31 August 2017

This application has been prepared by Ethos Urban on behalf of Mirvac Projects Pty Ltd (Mircac), pursuant to section 96(1A) of the *Environmental Planning and Assessment Act 1979* (EP&A Act) to modify Development Consent SSD 7317 which relates to the development of a commercial campus at the Australian Technology Park, Eveleigh.

The purpose of this modification request is to seek approval for the placement of mechanical exhausts, flues, vents and photovoltaics on top of the roof of Building 1 and amend the wording of Condition A14 accordingly.

Level 08 Plant GA Plan

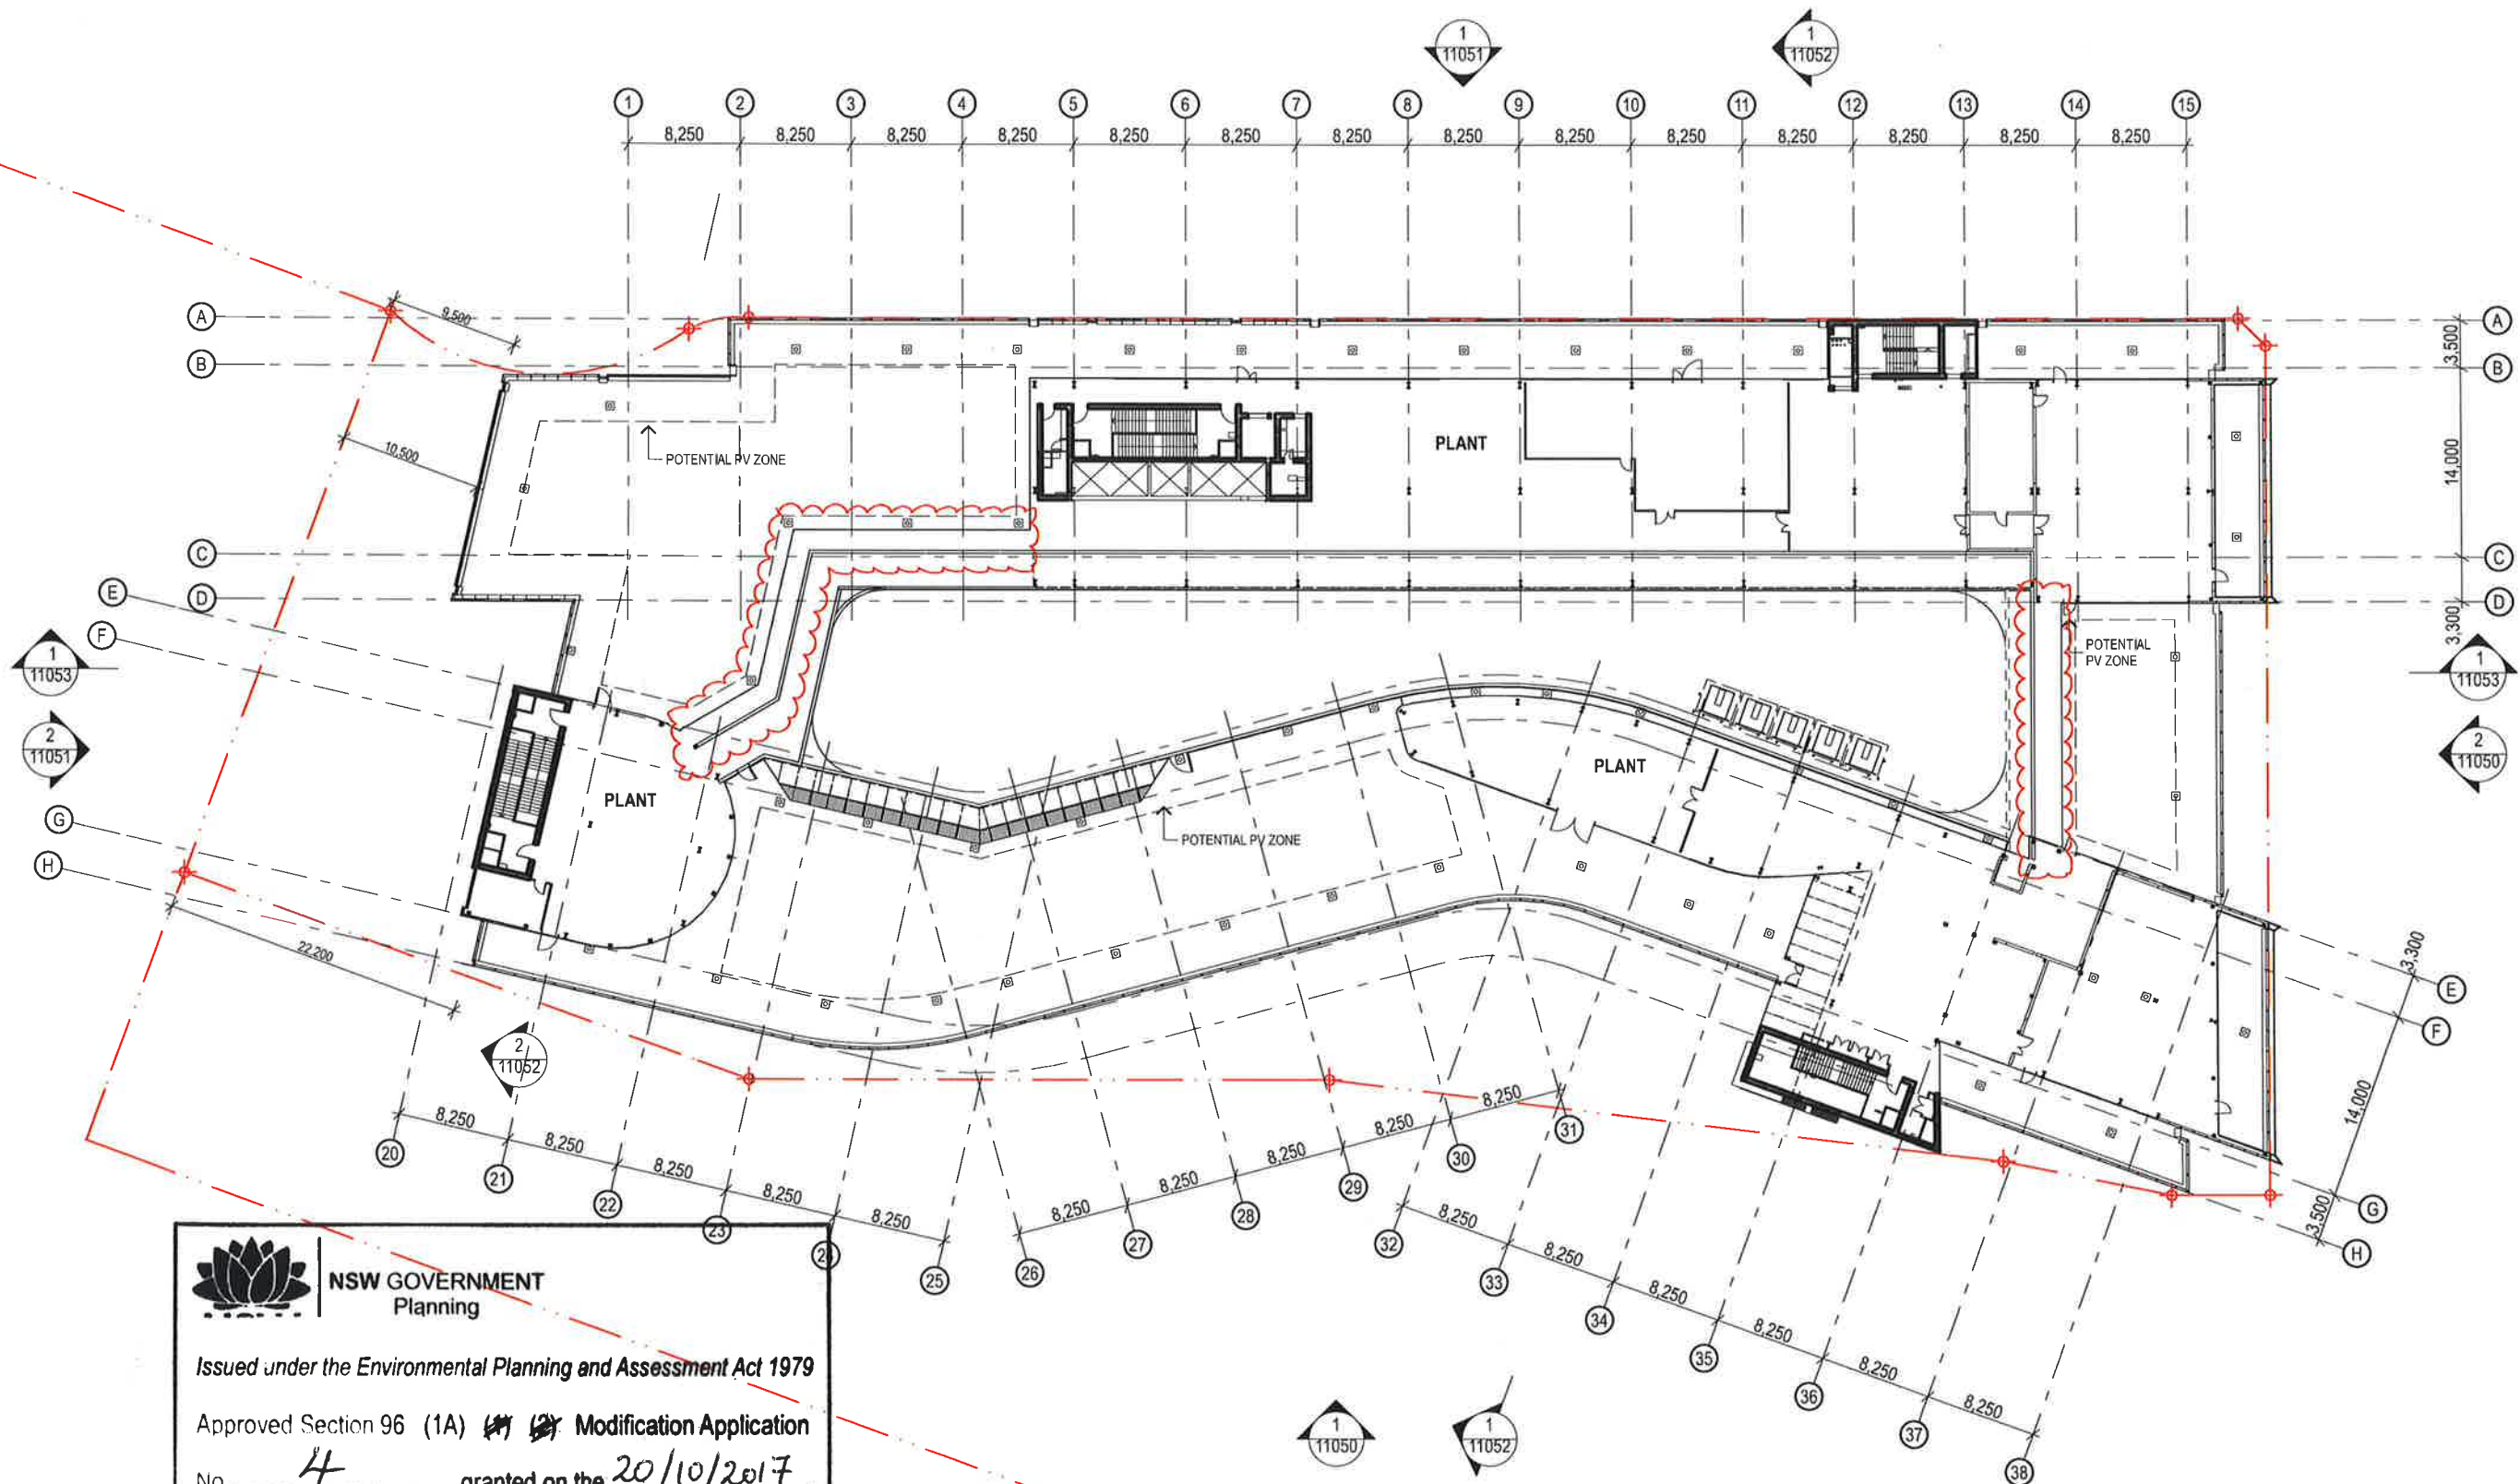
Due to design development and the requirements of mechanical exhaust design, Mirvac seeks approval to locate mechanical exhausts, vents and photovoltaics (PVs) on top of the roof of Building 1. The proposed locations of the exhausts, vents and photovoltaics and their maximum heights are illustrated on the revised Architectural Drawings prepared by FJMT (**Attachment A**).

<b>Drawing No.</b>	<b>Rev</b>	<b>Name of Plan</b>	<b>Date</b>
<b>Fjmt-AR-DWG-11008</b>	<b>DA1</b>	<b>Level 08 Plant GA Plan</b>	<b>27.04.16</b>
<b>Fjmt-AR-DWG-11009</b>	<b>DA1</b>	<b>Roof Plan</b>	<b>27.04.16</b>
<b>Fjmt-AR-DWG-11050</b>	<b>DA4</b>	<b>Elevations – South &amp; East</b>	<b>22.03.17</b>
<b>Fjmt-AR-DWG-11051</b>	<b>DA1</b>	<b>Elevations – North &amp; West</b>	<b>27.04.16</b>
<b>Fjmt-AR-DWG-11008</b>	<b>DA5</b>	<b>Level 08 Plant GA Plan</b>	<b>25.07.17</b>
<b>Fjmt-AR-DWG-11009</b>	<b>DA7</b>	<b>Roof Plan</b>	<b>25.07.17</b>
<b>Fjmt-AR-DWG-11050</b>	<b>DA7</b>	<b>Elevations – South &amp; East</b>	<b>25.07.17</b>
<b>Fjmt-AR-DWG-11051</b>	<b>DA7</b>	<b>Elevations – North &amp; West</b>	<b>25.07.17</b>

Roof Plan

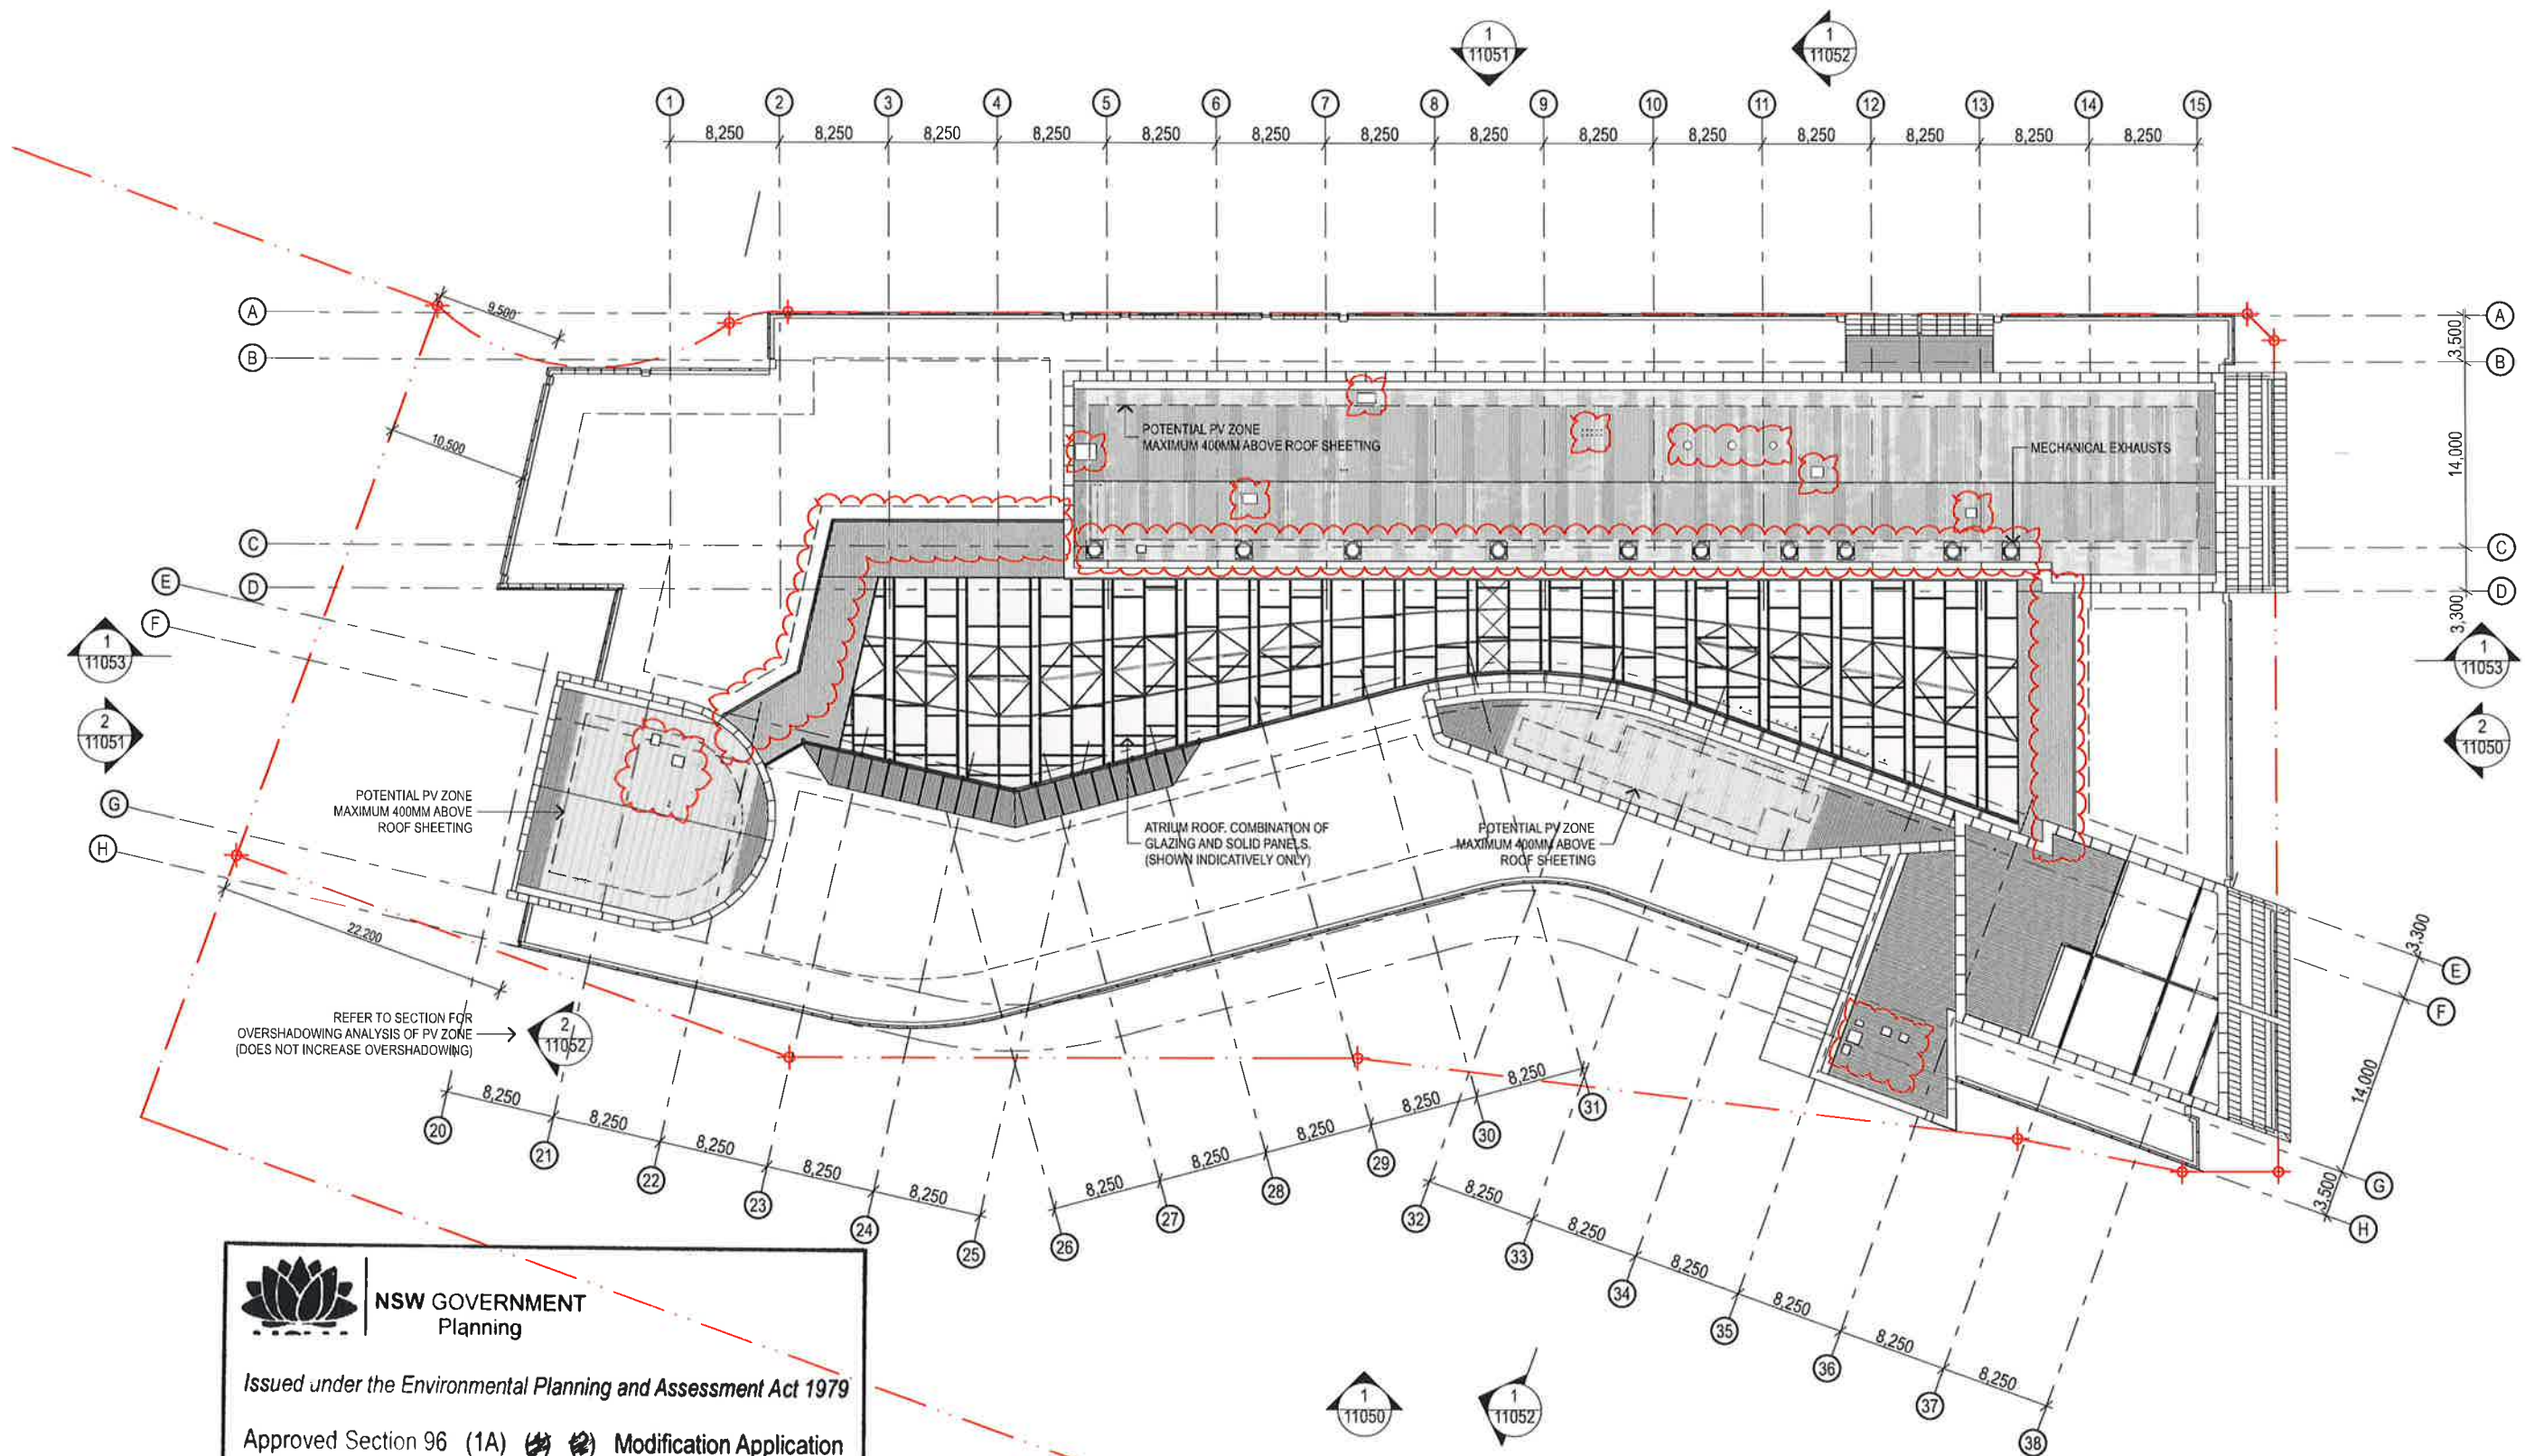
In developing the design for Building 1, it became apparent that to provide effective dispersion, the mechanical exhausts and flue/vent infrastructure would need to be a minimum of 1.565m and 3m higher than the roof level of the building respectively. Furthermore, the positioning of the photovoltaics is also required to be positioned approximately 400mm above the roof sheeting level.

For the purposes of controlled activities within the protected airspace of Sydney Airport, Building 1 must not exceed a maximum height of ~~57.9m~~ **60.9m** AHD, inclusive of all lift over-runs, vents, chimneys, aerials, TV antennae, lightning rods, any roof top garden plantings, exhaust flues etc.
